City of Portland, Maine - Building or Use Permit

Permit No: 2013-00884	Date Applied For: 05/02/2013	CBL: 149 G006001
---------------------------------	--	----------------------------

Location of Construction: 159 CANCO RD	Owner Name: CITY OF PORTLAND	Owner Address: 389 CONGRESS ST	Phone:
Business Name: Trust for Public Land	Contractor Name: Maine Bay Canvas	Contractor Address: 53 Industrial Way Portland	Phone (207) 878-8888
Lessee/Buyer's Name Lisa Preble	Phone: 2077727424	Permit Type: Tents

Proposed Use: Park	Proposed Project Description: Erect 20' x 30' tent on Friday, May 3, 2013 and breakdown on Monday, May 6, 2013.
------------------------------	---

Inside  
tent layout  
proposed

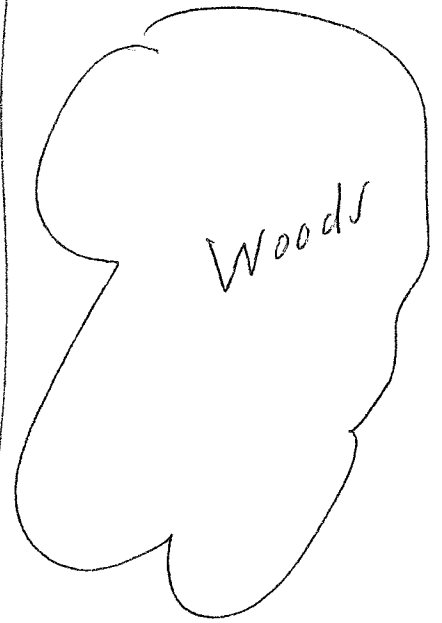
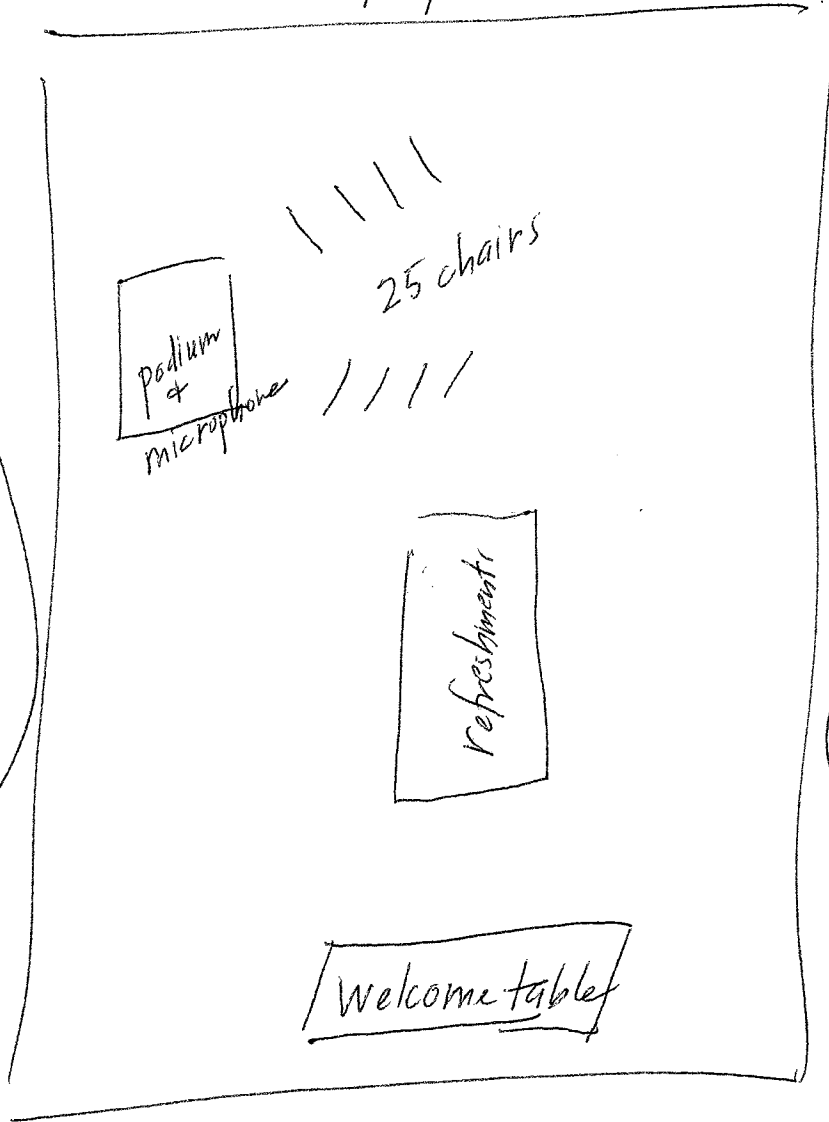
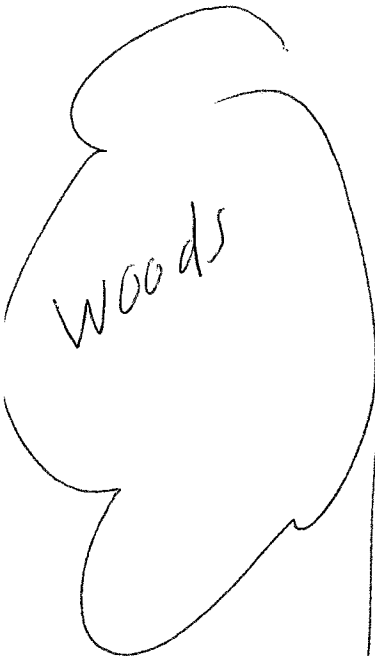
- 1) If the sides of the tents are to be enclosed at least two remotely located and marked exits shall be provided.
- 2) Cooking within the tents has not been reviewed and approved.
- 3) If the sides of the tents are to be enclosed at least two remotely located and marked exits shall be provided.
- 4) Tents shall have an approved fire resistant rating and maintain 10' between stake lines. No smoking or open flame allowed within 10'. Provide at least one 2A:10 BC fire extinguisher.
